From: Kathryn Welch
Sent: 16 March 2022 09:58
To: Planning Scanning
Subject: FW: Pharos Quay, River Road, Littlehampton - LU/13/22/PL

1. PVCu replacement windows, in principle, would receive your support. Not high gloss finish but with timber woodgrain effect as specified.
2. You are supportive, in principle, of casements and do not see the need for varying the style to vertical sliding sash windows.

3. We discussed advantages of 'horns' on the base of the upper casements but do not feel they add anything to the overall design.
4. I have drafted up a drawing of a typical window (W10) in the existing and proposed format for your assistance. Hope this helps.

1. Design for safety in use.
2. Means of escape from fire.
3. Security from unauthorized entry.
4. Design for safety when cleaning (the minimum height for incorporation of transoms (safety rails in windows above floor level in high rise buildings, two storey's and above).
5. Maintenance.

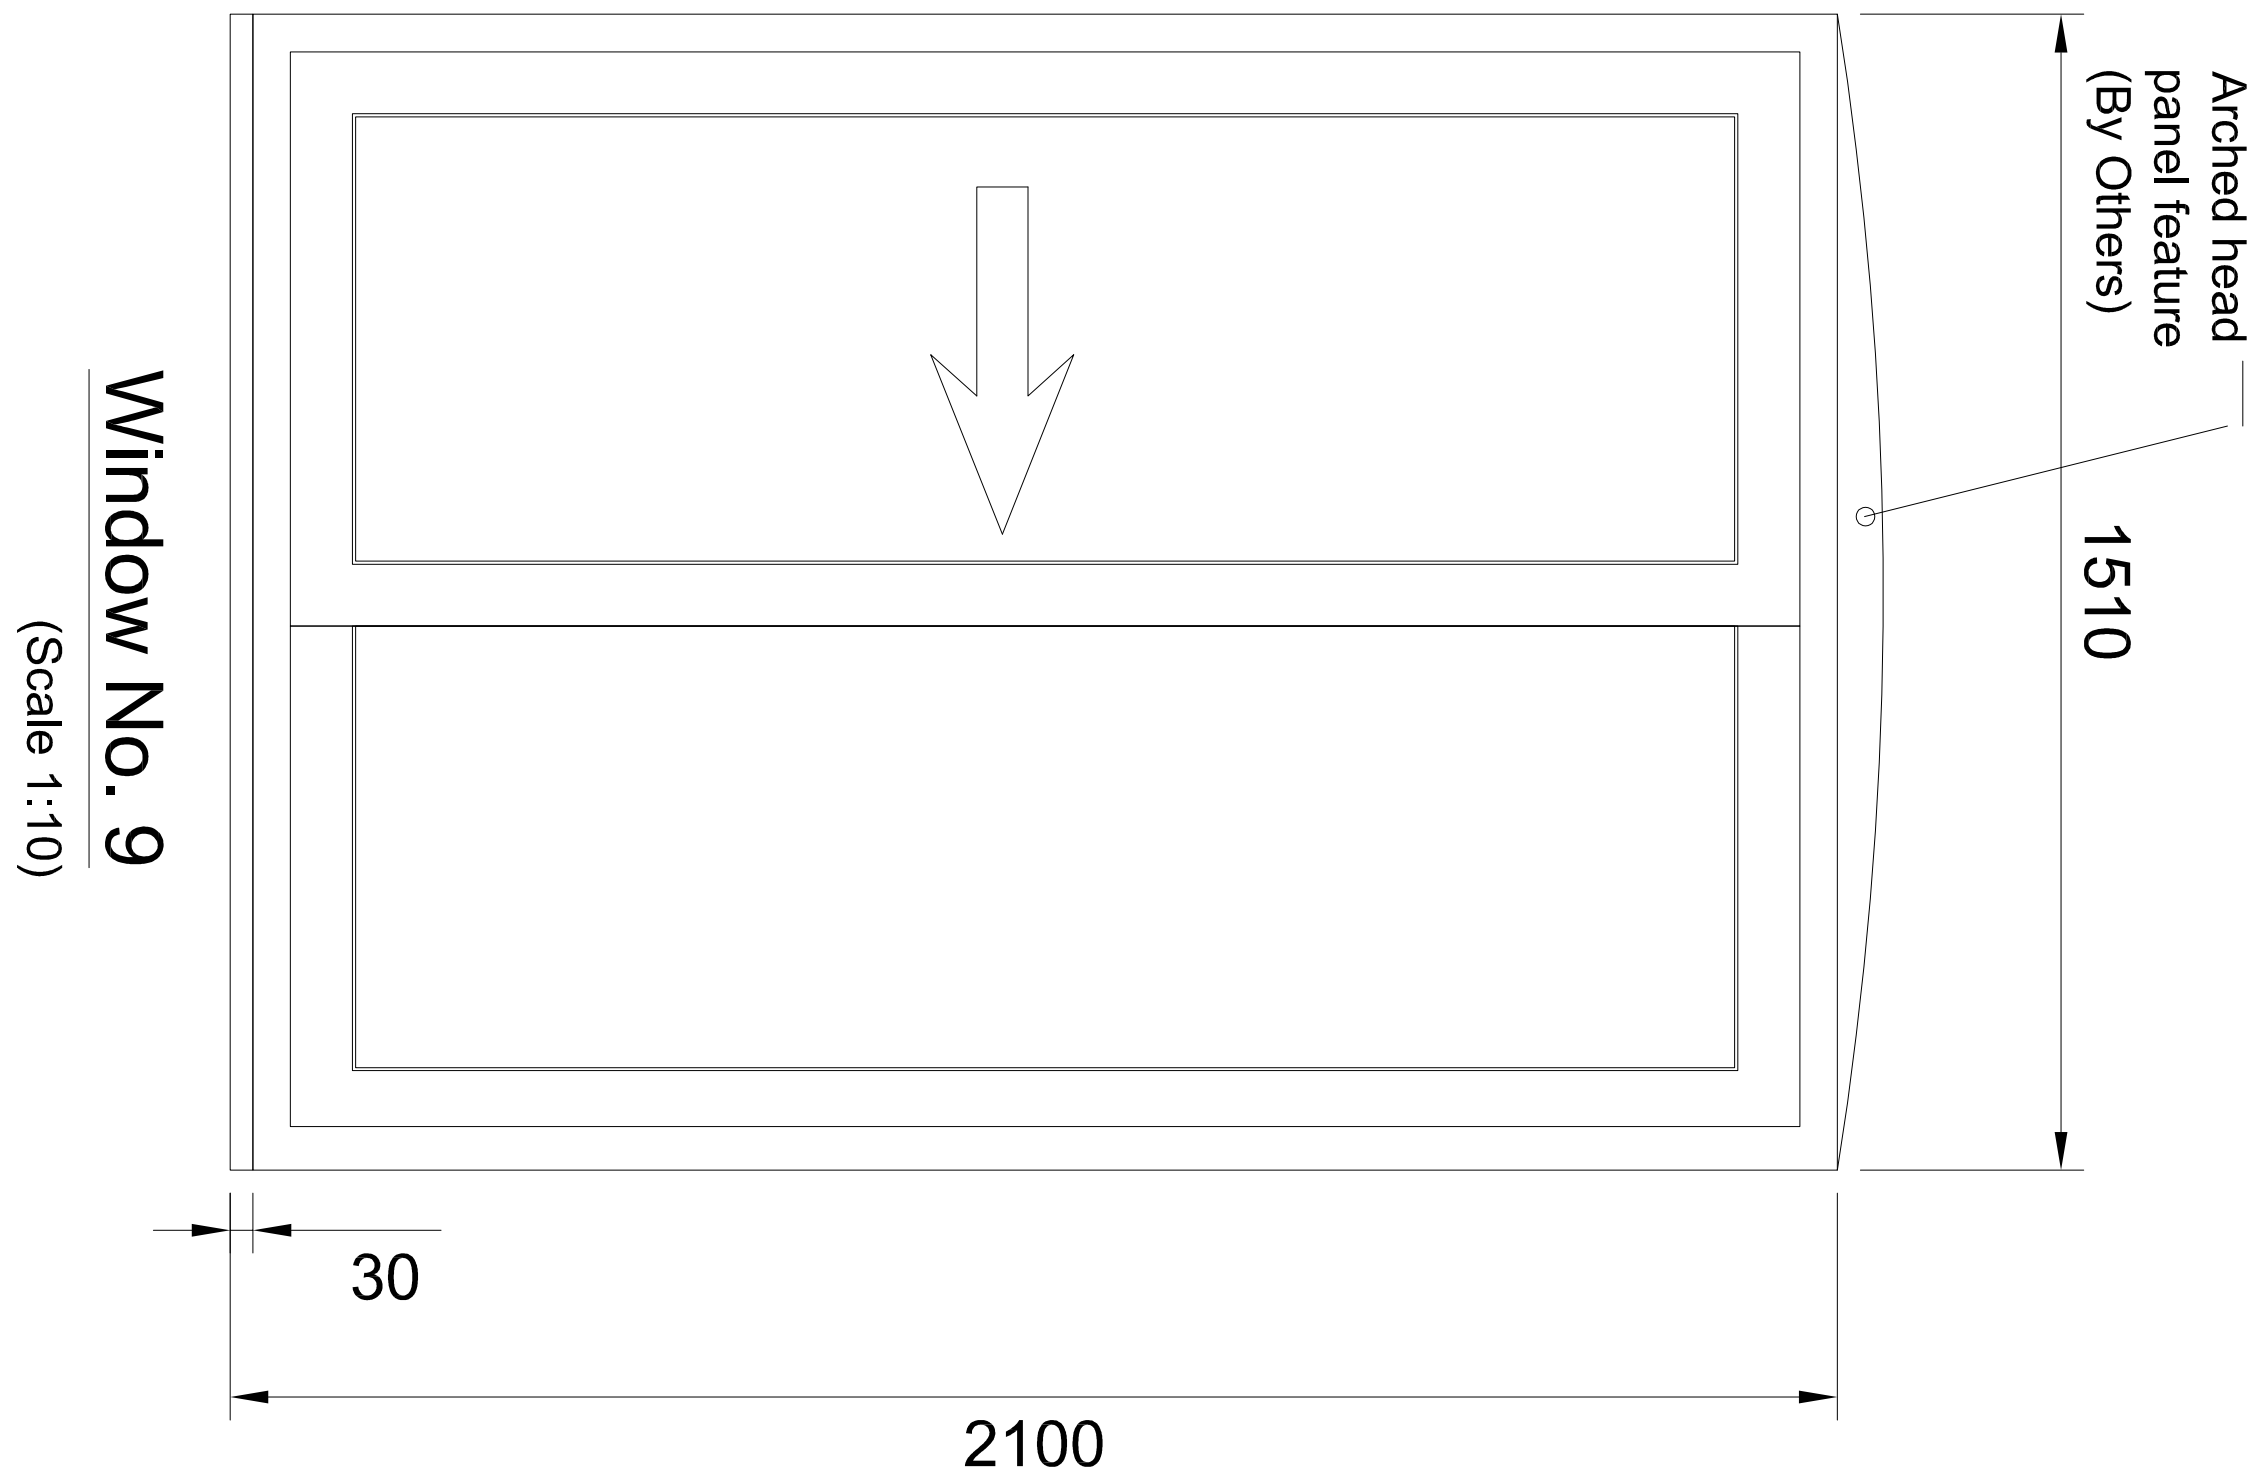
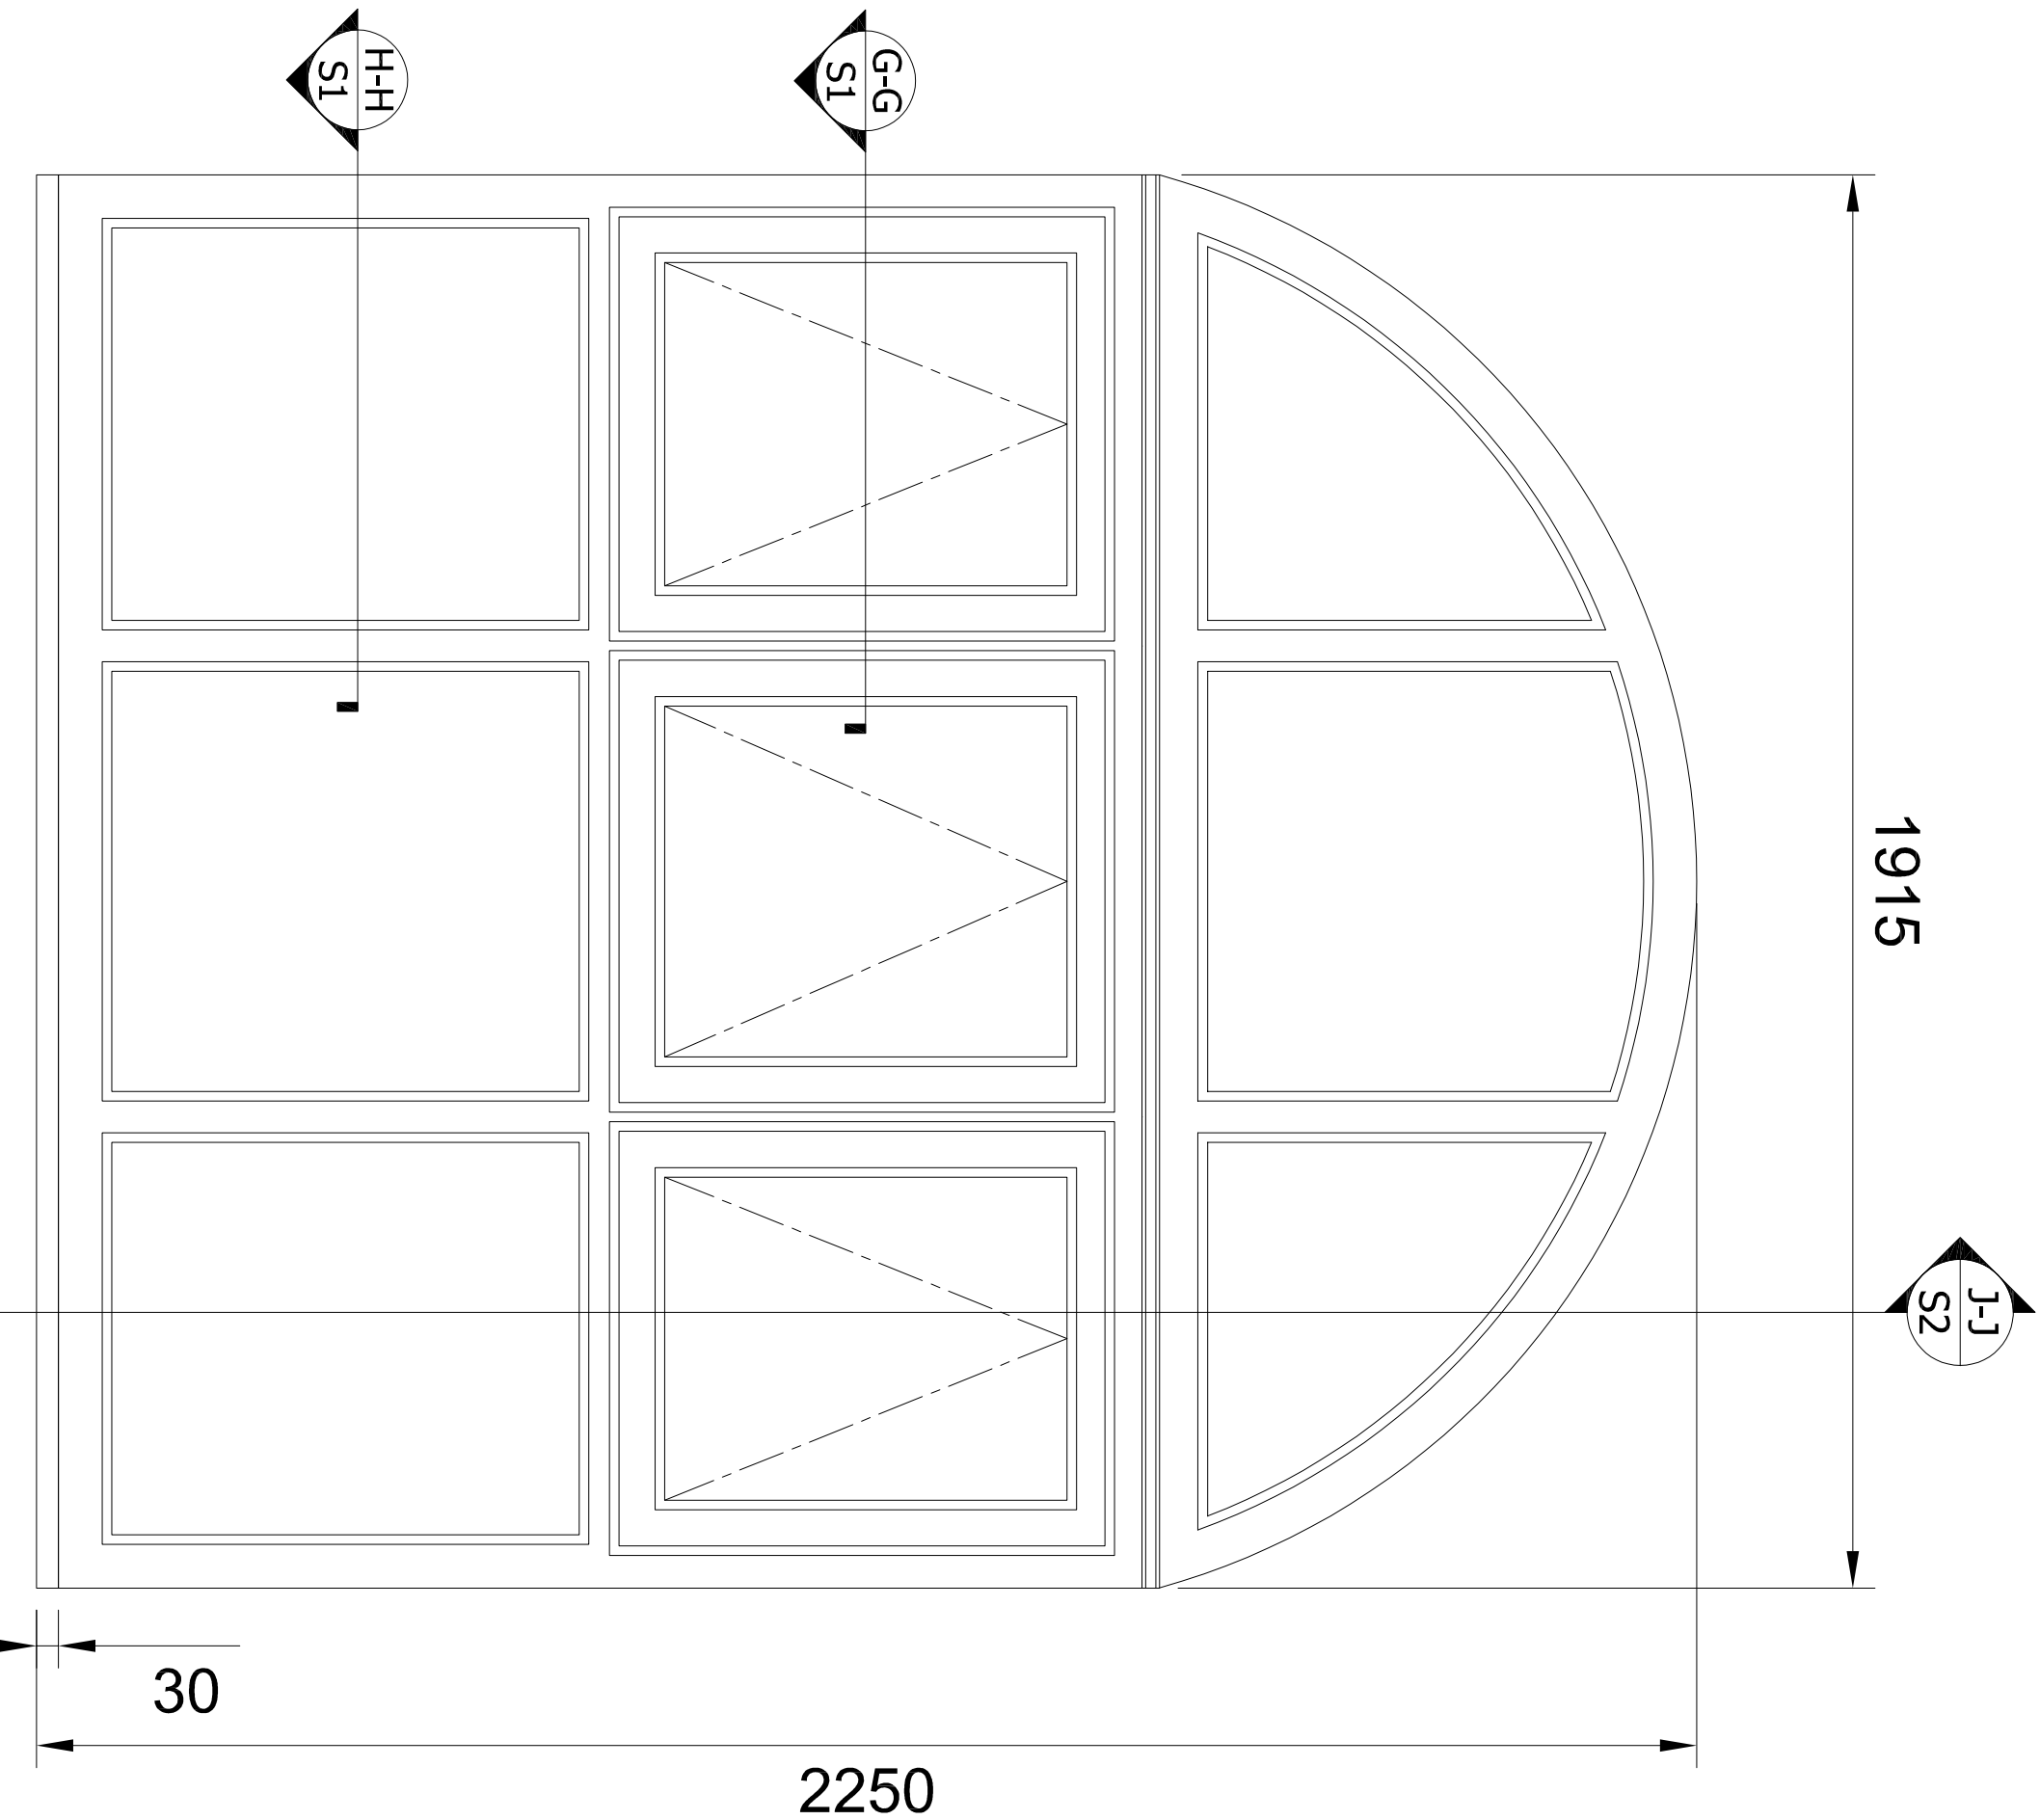
The details sent through for point 4 still look a little 'chunky' to me. As I said over the phone, in order to utilise Upvc windows in heritage locations we normally stipulate heritage glazing, where not only are the glazing profiles slimmer but the frames also. It has been very useful to see the side-by-side comparison, my biggest concern is the upper opening part of the window and not the fixed pane at the bottom, it is significantly larger than the existing timber frame. Is this something that can be rectified? If this can't be done in time I happy to approve with a condition for further details.
